**Kellyville South Public School (SSD 7787)
Notice of Exhibition**

TAB A – Request for Further Information/Clarification

PROPOSED SITE PLAN

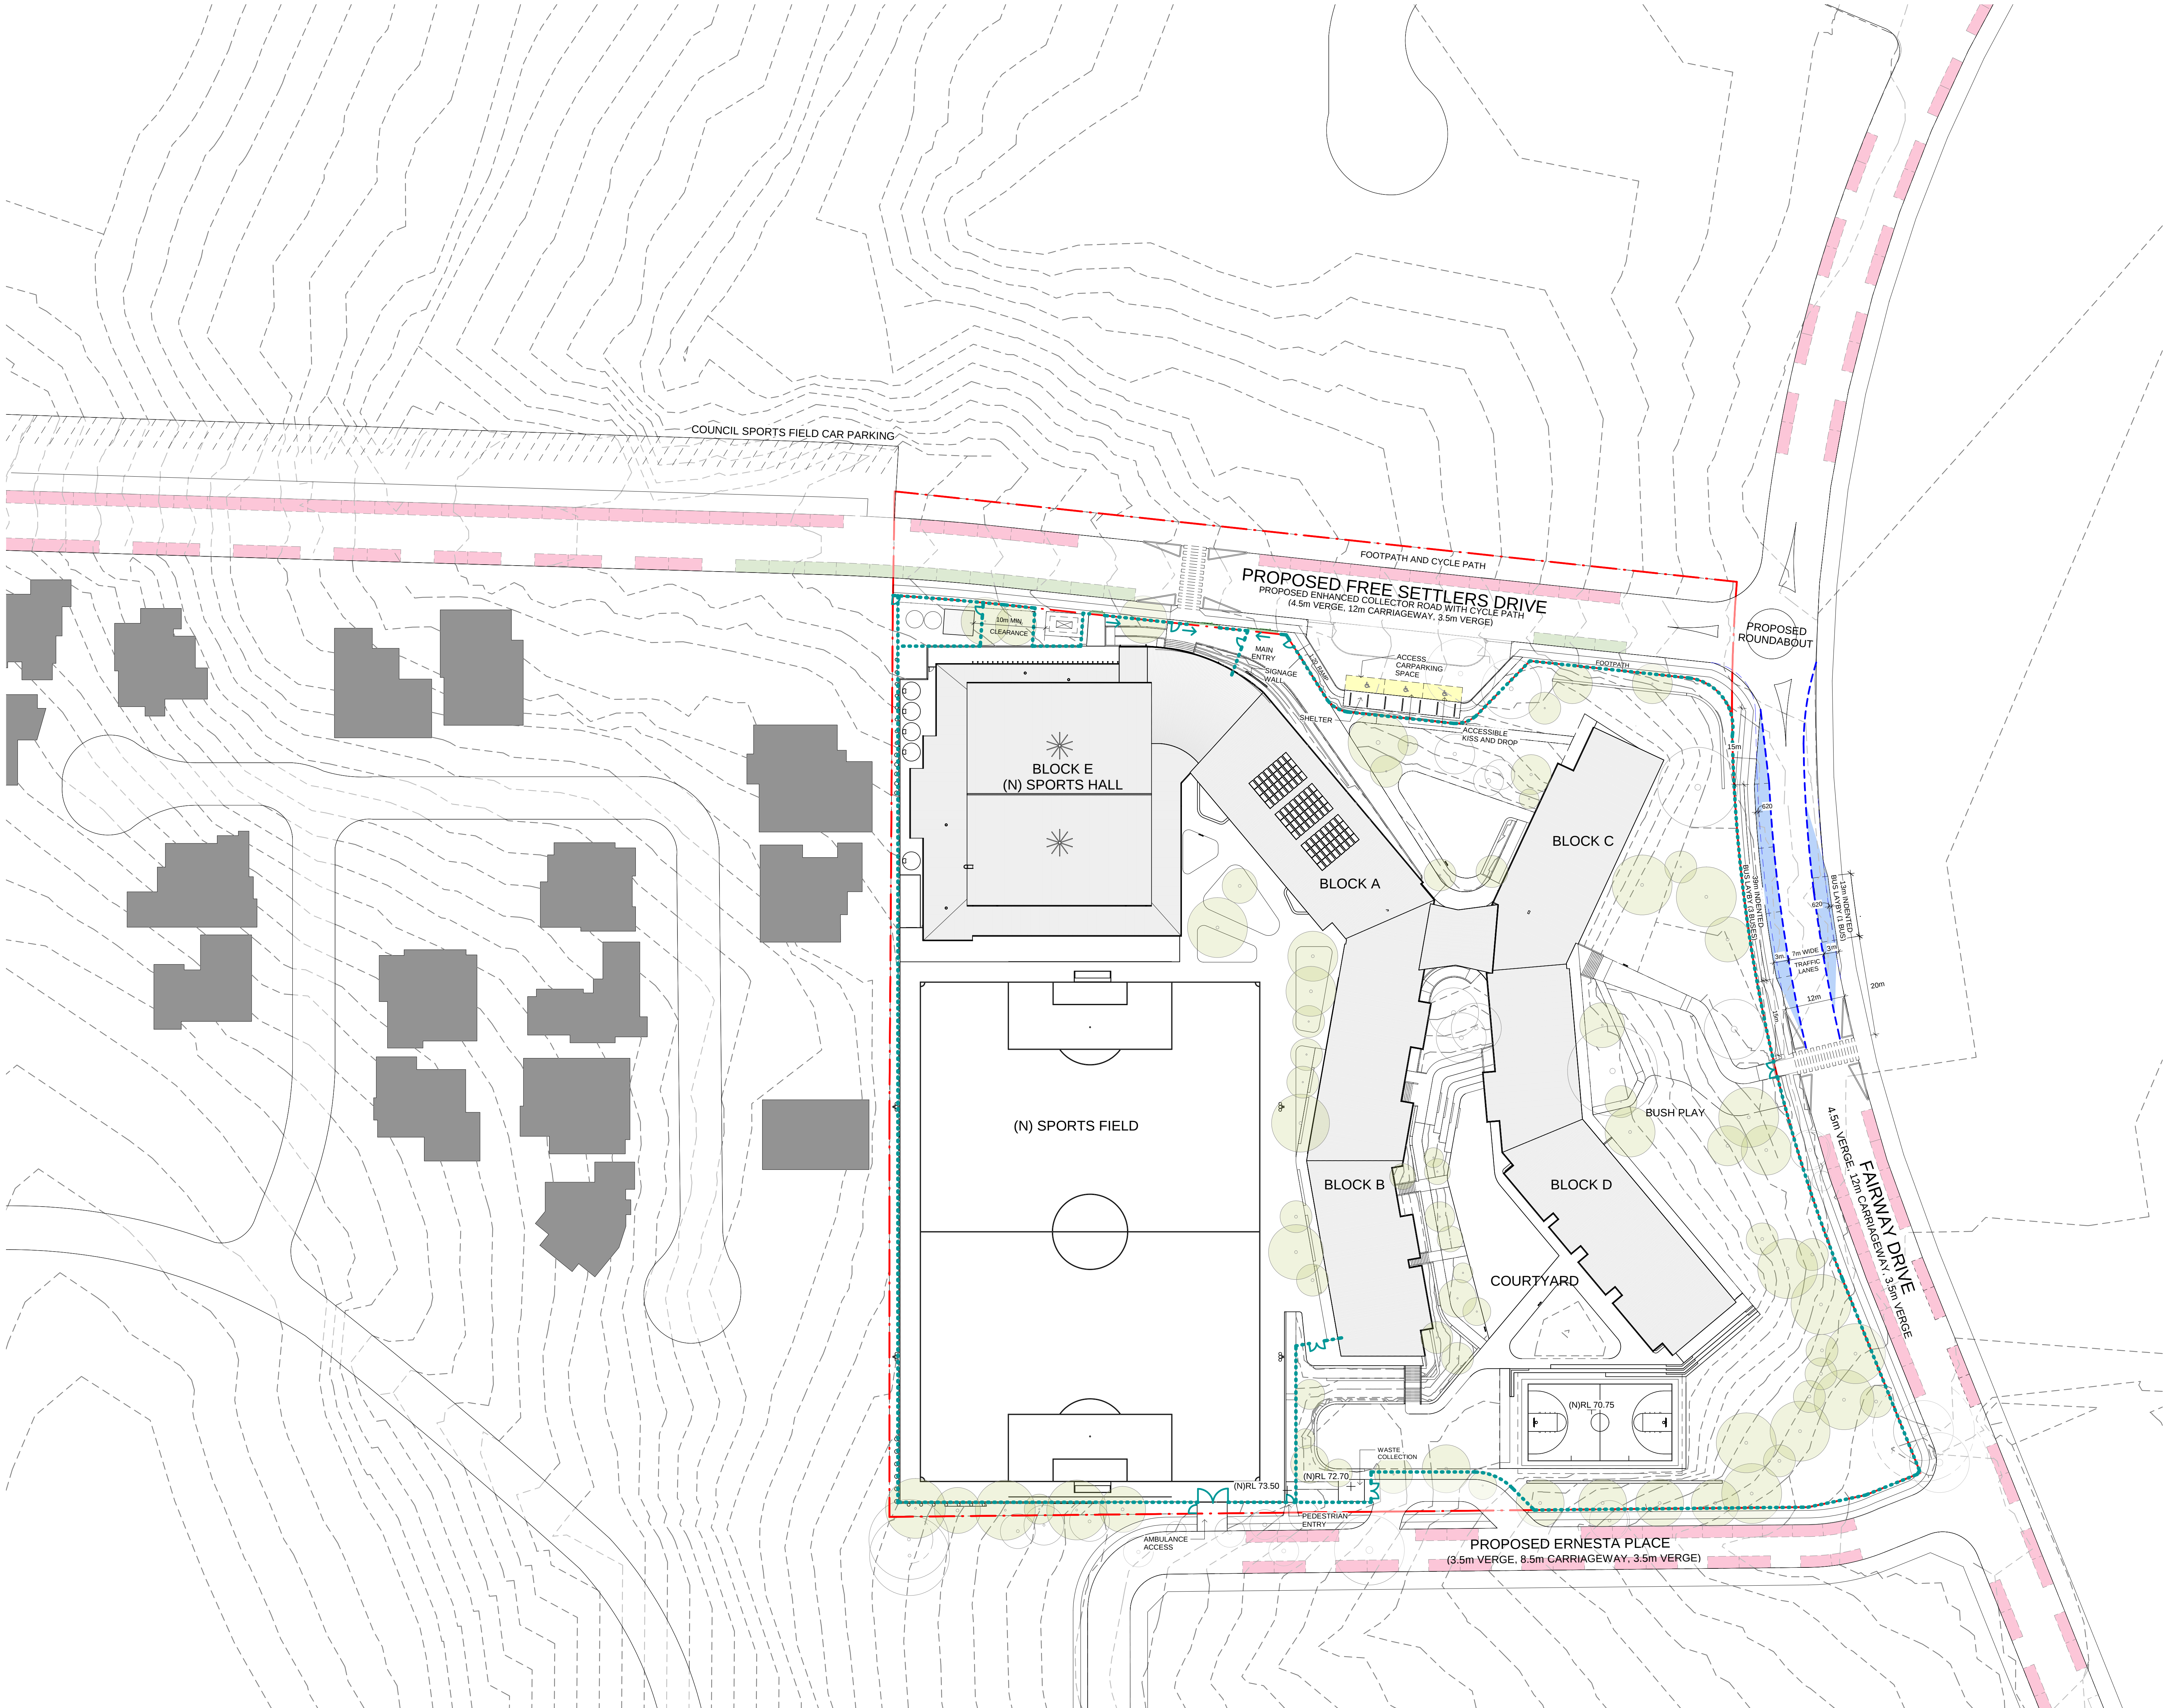
Two bus zones have been proposed along Fairway Drive at the site's eastern frontage. The proposed bus zones have been designed as follows:

- Both bus zones have been designed with a width of 2.4m and length of 30m, capable of accommodating two buses at each stop.
- One bus zone is to be located on the western side of Fairway Drive, with vehicle entry/exit facing the school.
- A second bus zone is to be located on the eastern side of Fairway Drive, with vehicle entry/exit facing the eastern side of Fairway Drive. This arrangement requires passengers to/from the school to cross the road to board and alight from buses waiting at this stop.

TfNSW does not support this design outcome as it increases the potential conflicts between students, bus operations and general traffic.

- The proposed bus zone arrangement is revised to accommodate an indented bus zone along the Fairway Drive school frontage allowing unconstrained access for students moving between the school and the bus zone.
- The indented bus zone should have a width of 3.0m and be capable of accommodating four buses. A detailed design plan of the proposed drop-off/pick-up zone should be provided to TfNSW for evaluation.
- The bus zone should be positioned after the proposed pedestrian crossing and positioned away from the private vehicle pick-up/drop-off area.
